CONSERVATION REFERRAL COMMENTS

Application Ref:	21/0025/PREAPP
Address:	Land East of 12 High Causeway, Whittlesey
DC Case Officer:	Alison Hoffman
Conservation Officer:	Claire Fidler
Date:	17th March 2021

GROUND FLOOR - Proposed 1:50

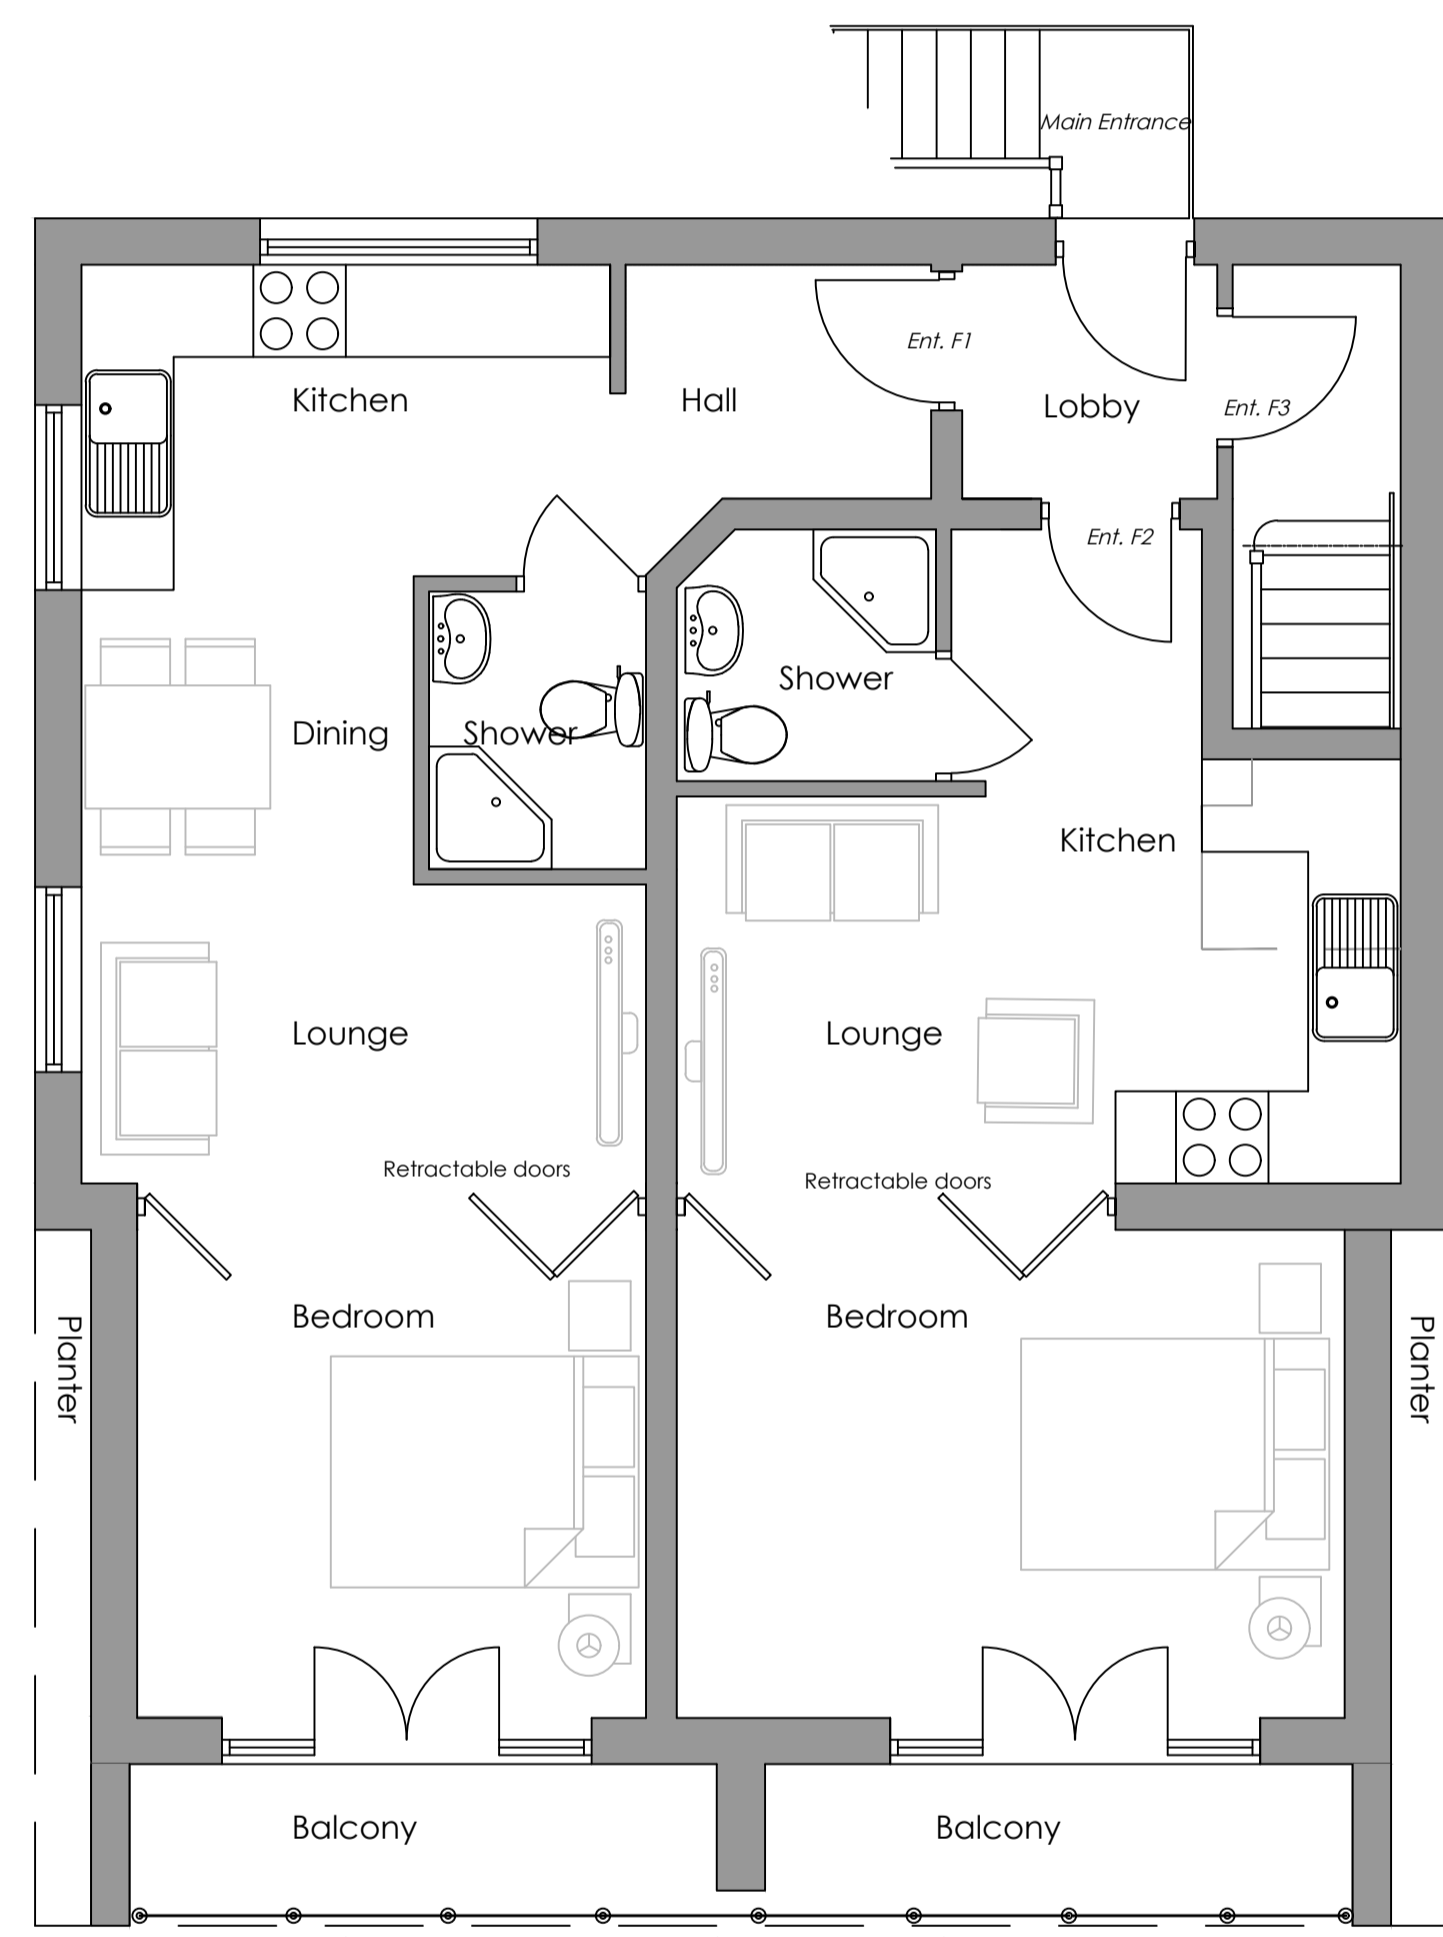
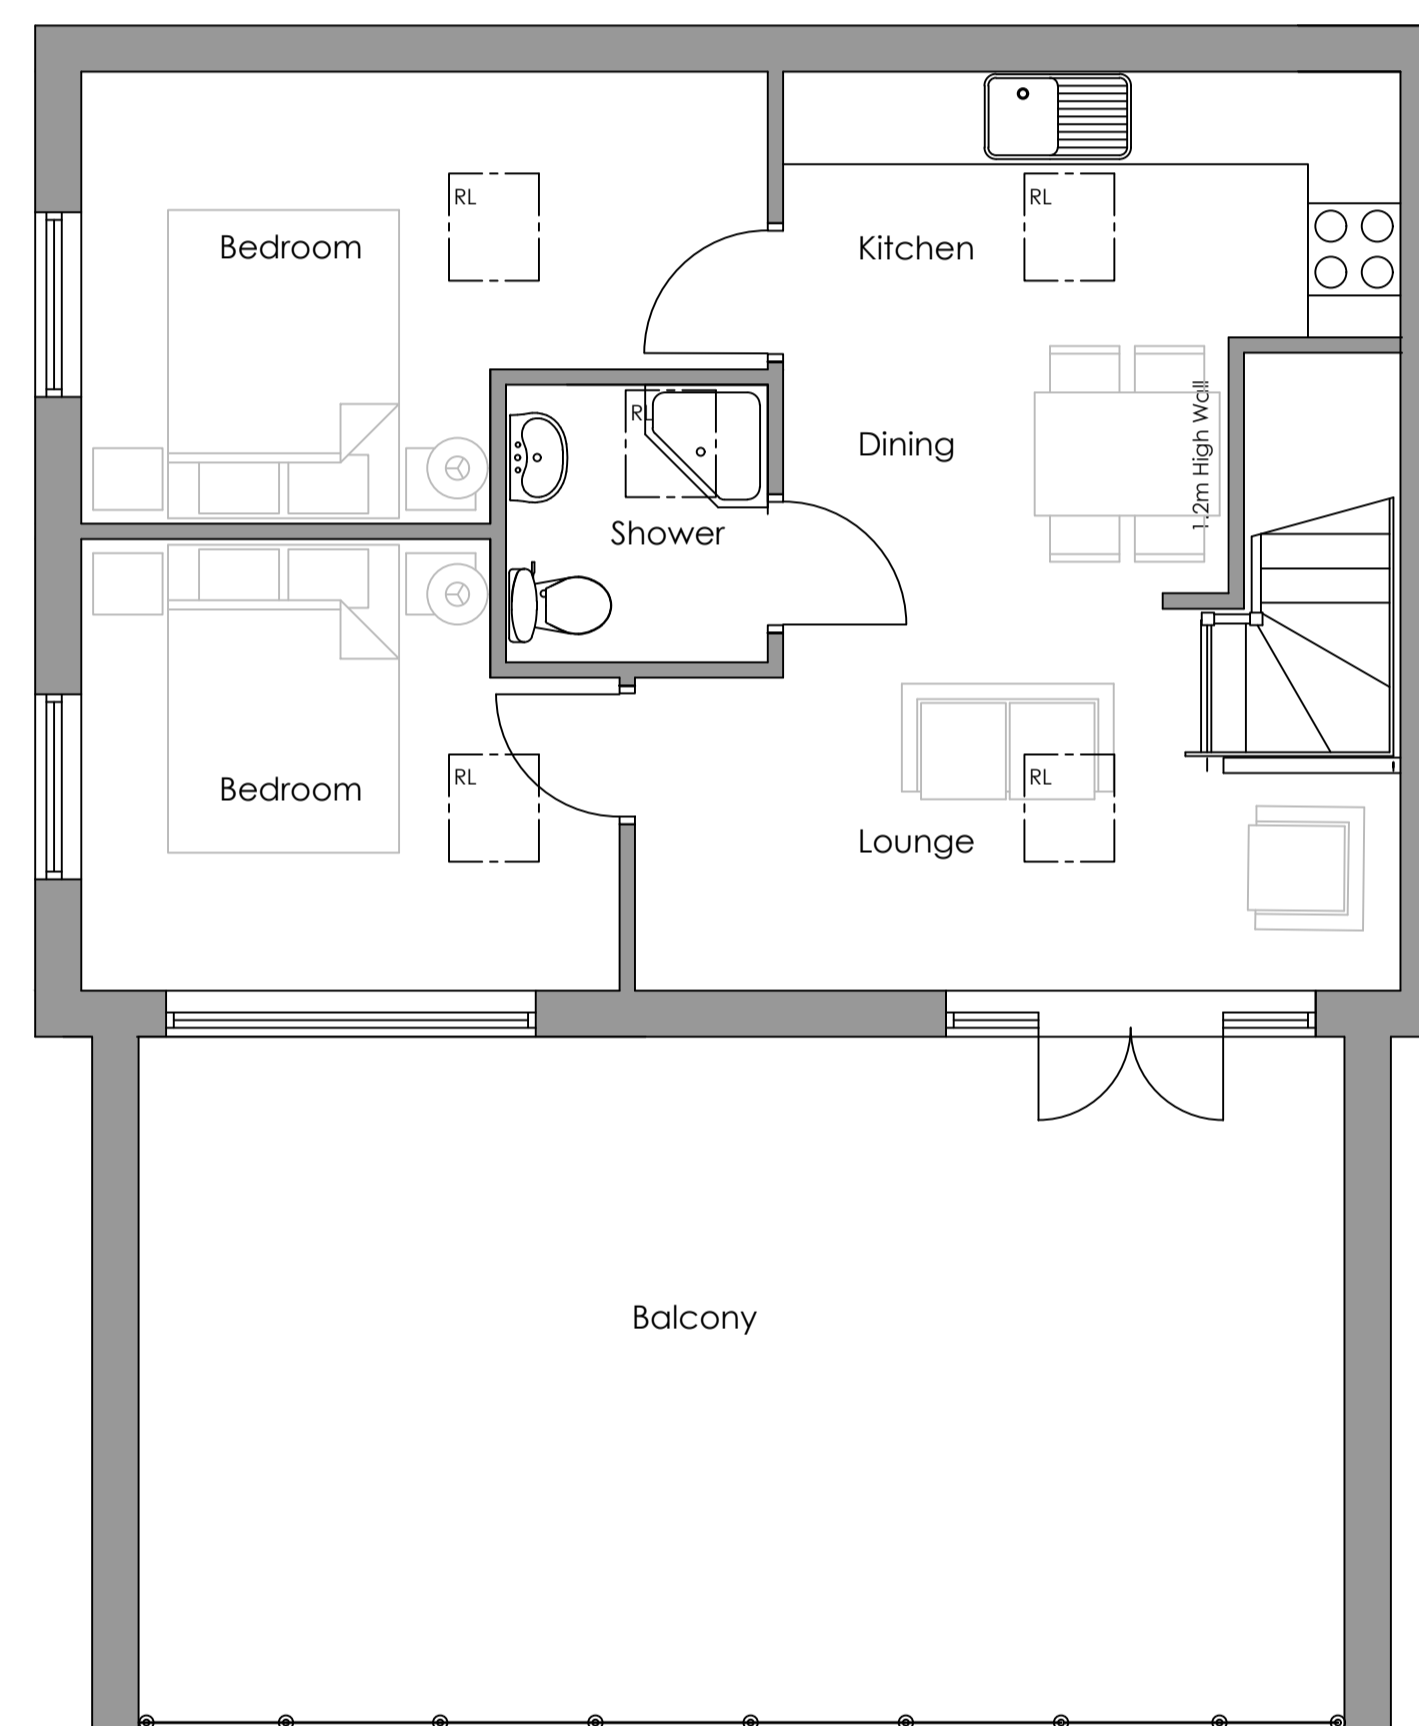
6. The design proposed, although not within the conservation area, could perhaps be improved by the removal of the undercroft parking with perhaps the area

currently designated for parking and turning designated instead for parking, so allowing an improved aesthetic for the design of the scheme. The materials suggested appear acceptable, though product details should be submitted to avoid future conditions and the use of a slate roof may be more appropriate in this location than a red tile roof.
